DELEGATED DECISION TO DETERMINE PLANNING APPLICATIONS

Reference No:	2026/62/91032/W
Site Address:	20, Rowley Hill, Common End Lane, Lepton, Huddersfield, HD8 0JF
Description:	Erection of first floor side extension incorporating dormer window and associated alterations
Recommending Officer:	Faiza Bano

Officer Report – 2026/90752

P04	Updated to suit KMBC comments	11.08.2026	STE	STE
P03	Planning Issue	12.04.2026	STE	STE
P02	Revised to suit Client comments	07.04.2026	STE	STE
P01	Issued for Client comment.	01.04.2026	STE	STE
Rev	Description	Date	Dr by	App by

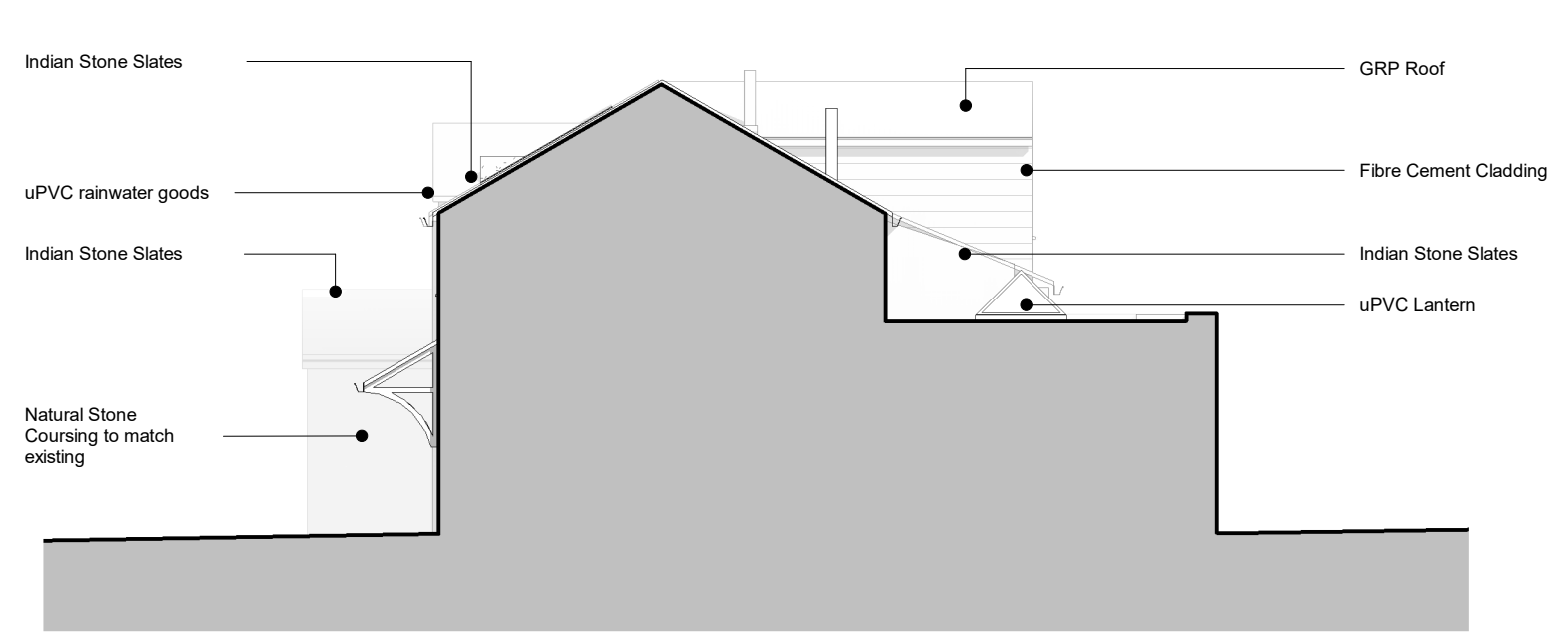
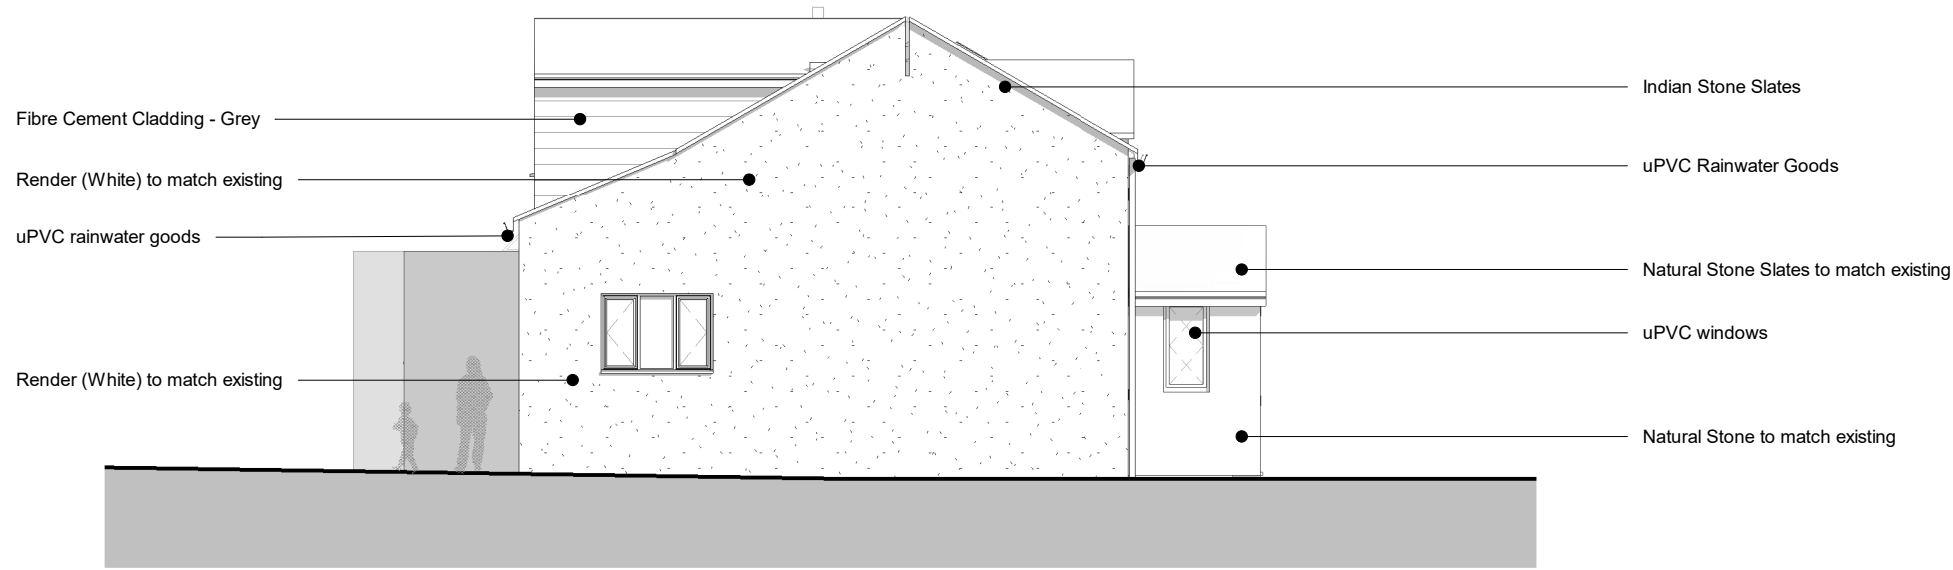
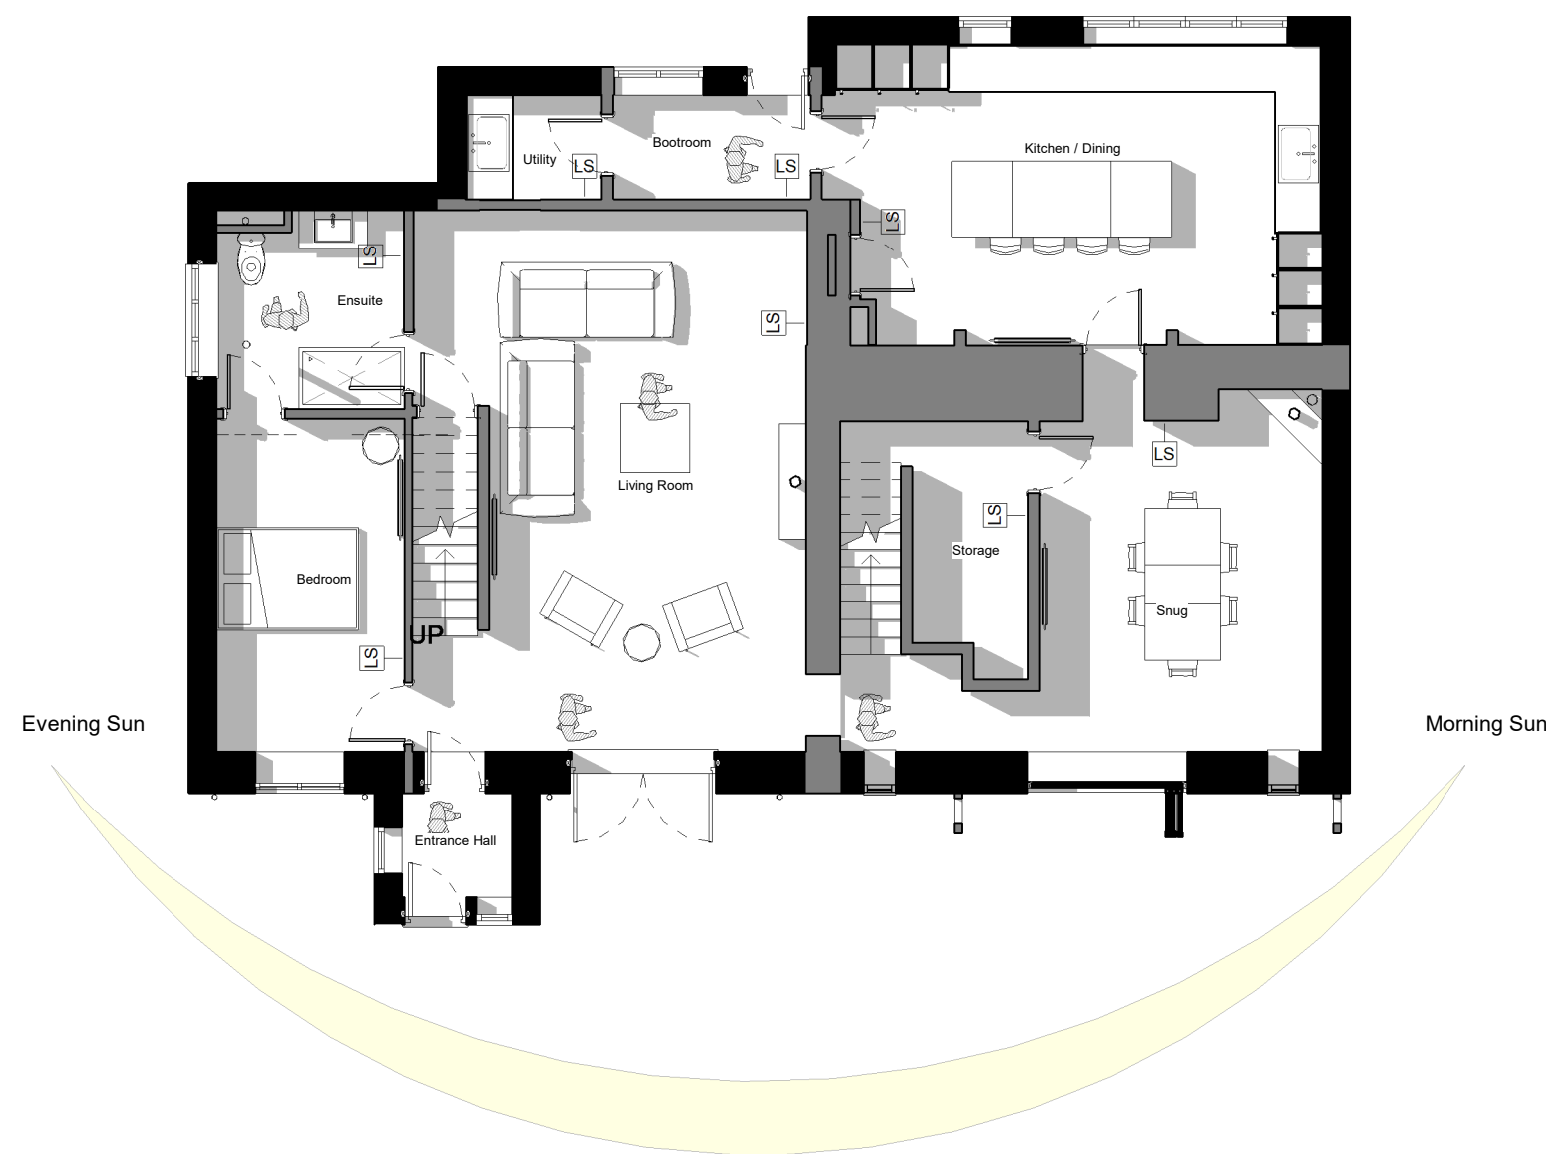
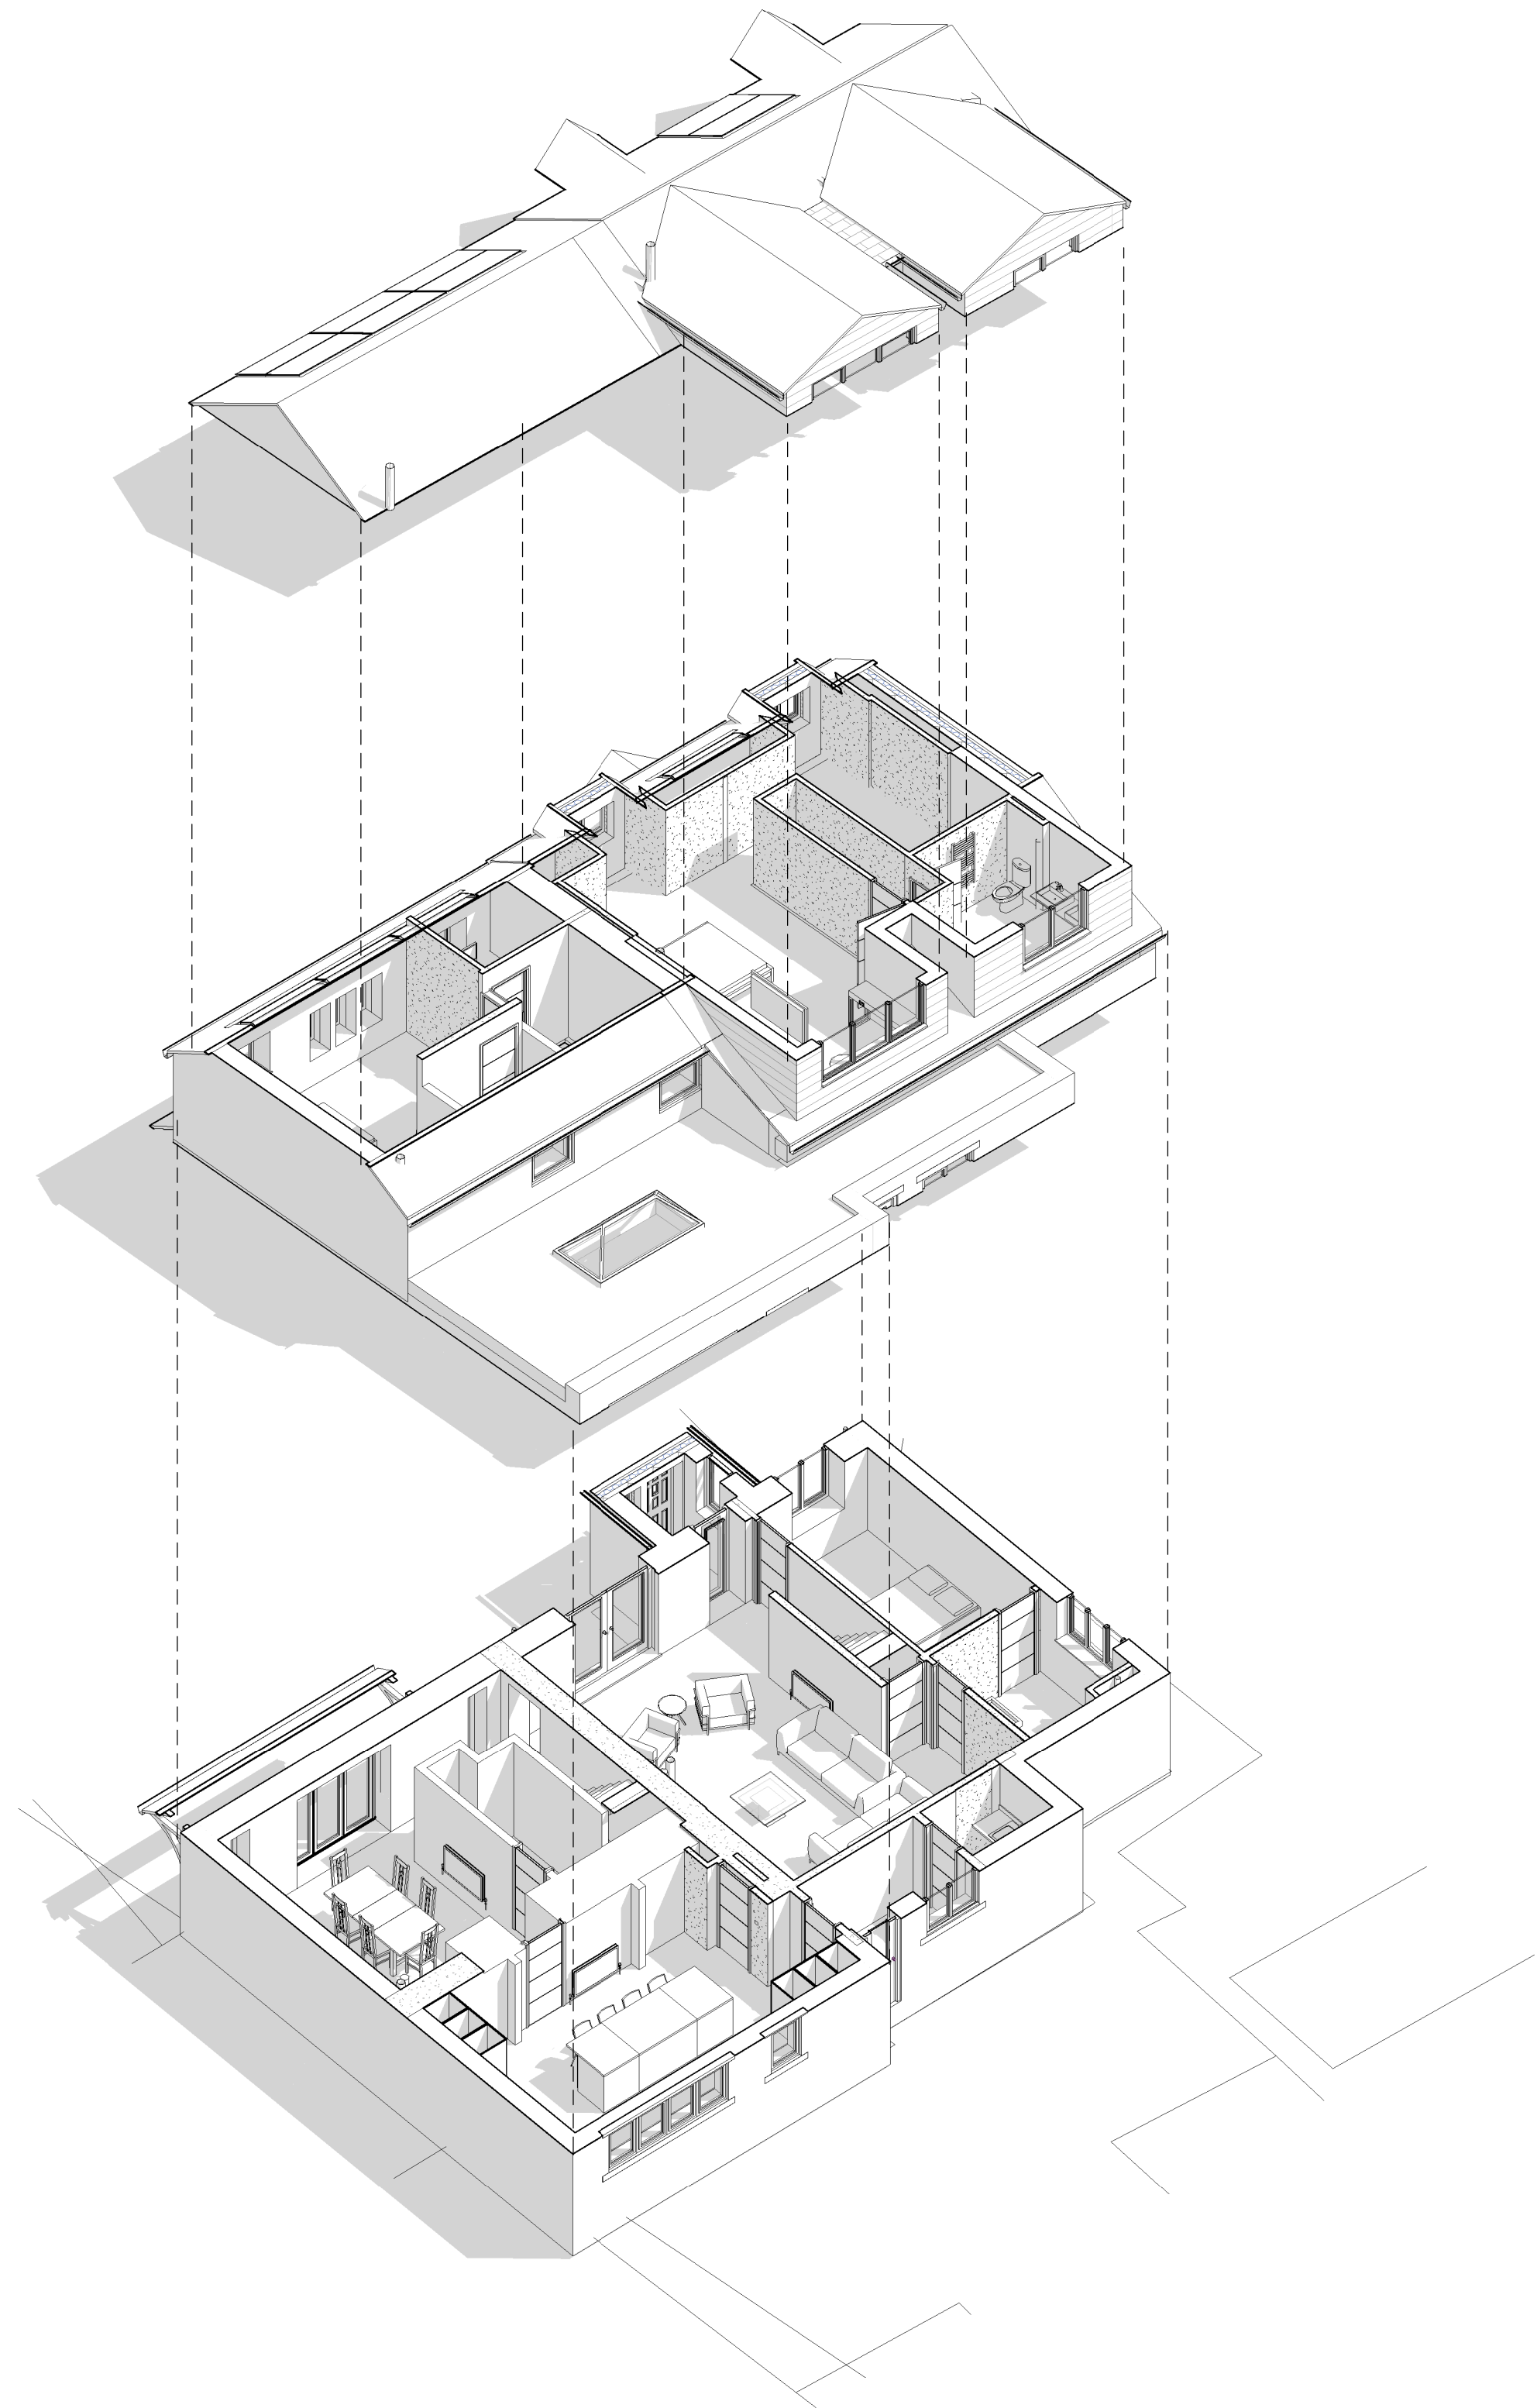
Amended plans were requested to change the design of the rear dormer. These were received, which were considered to address officers initial concerns.

Pursuant to article 35 (2) of the Town and Country Planning (Development Management Procedure) Order 2015 and guidance in the National Planning Policy Framework, the Local Authority have, where possible, made a preapplication advice service available, complied with the Kirklees Development Management Charter 2024 and otherwise actively engaged with the applicant in dealing with the application. Amended were sought to amend the scale and design of the dormer with satisfactory plans being submitted to address officers concerns.
